## **CITY OF PORTLAND**

August 6, 1999

CBL: 155-D-013

It was recently noted that your swimming pool was not installed in accordance with Section 421.0 of the 1996 BOCA Code as stipulated in your permit issued June 14, 1999.

51 BAY ST

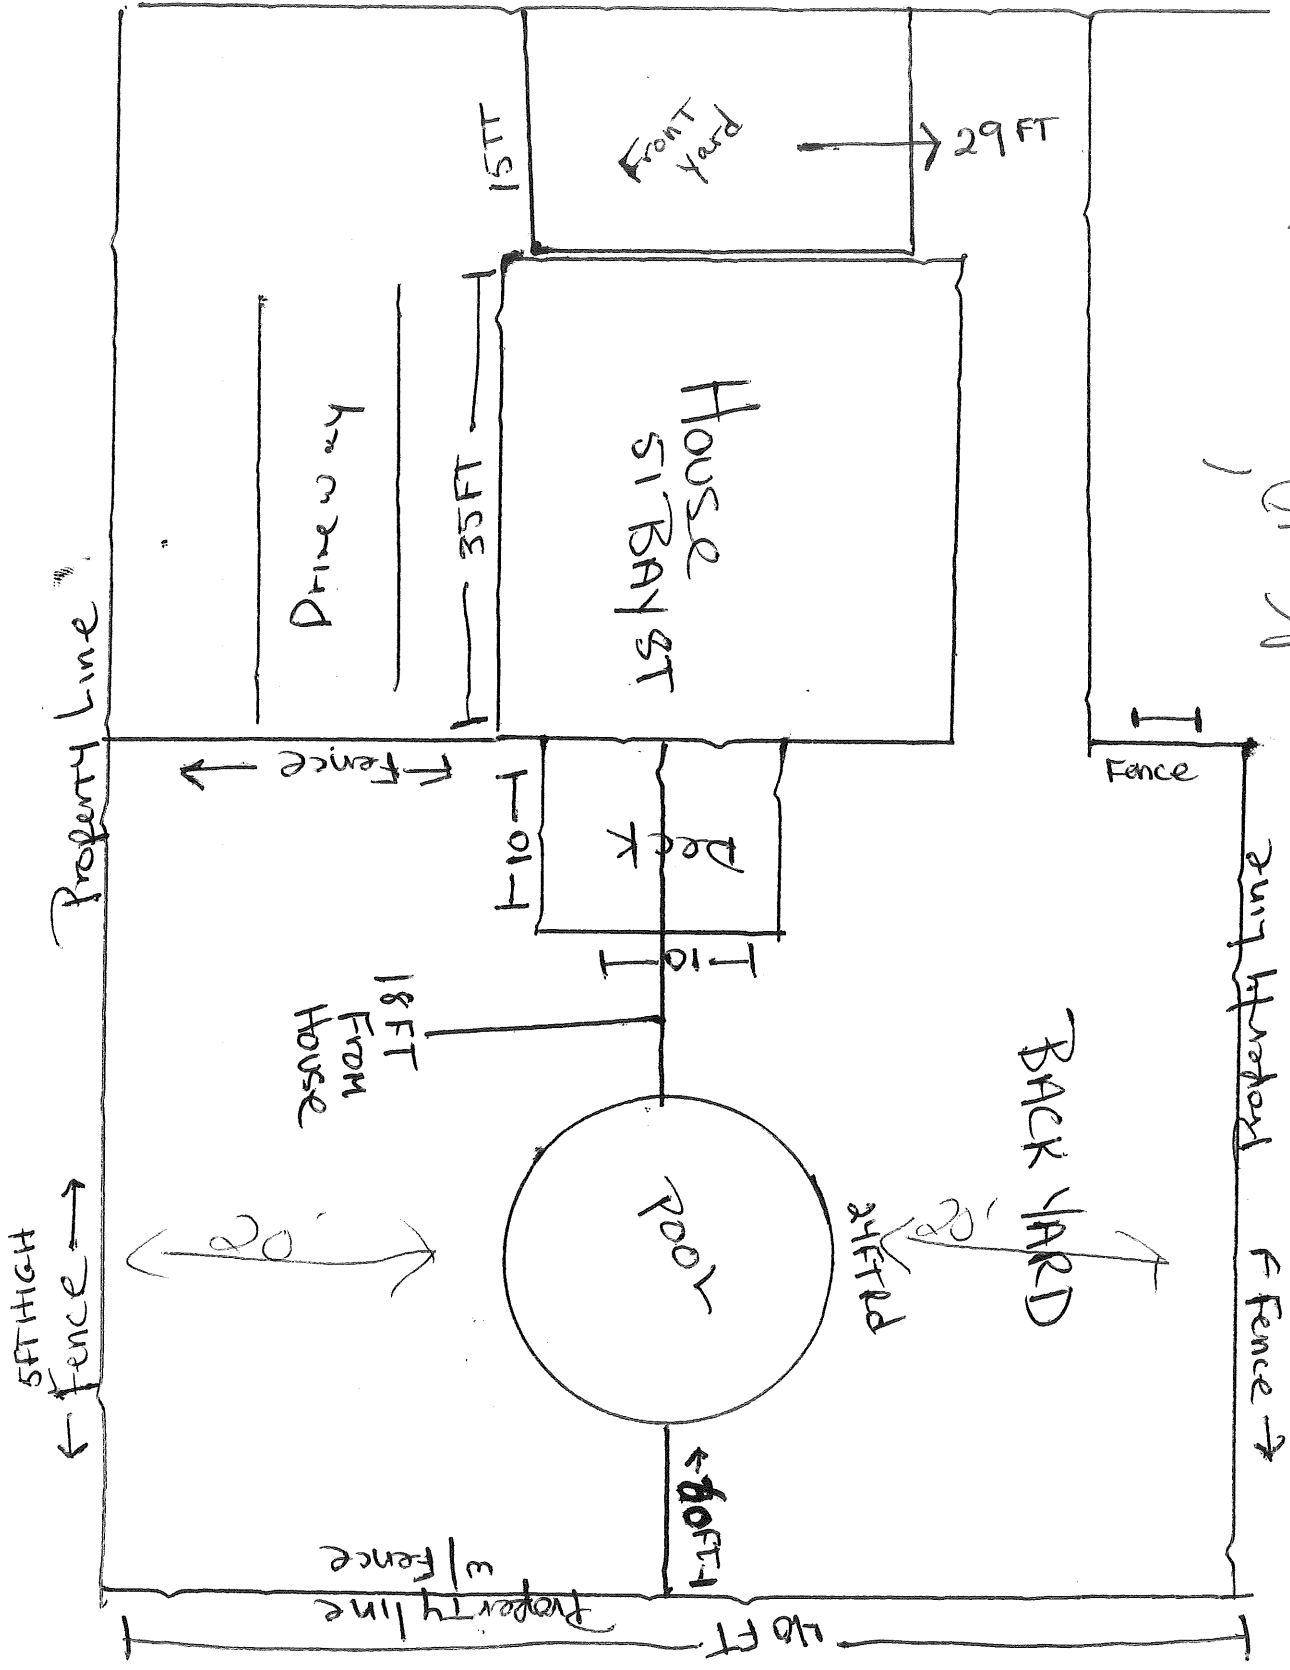
1. Chain fence – no protection
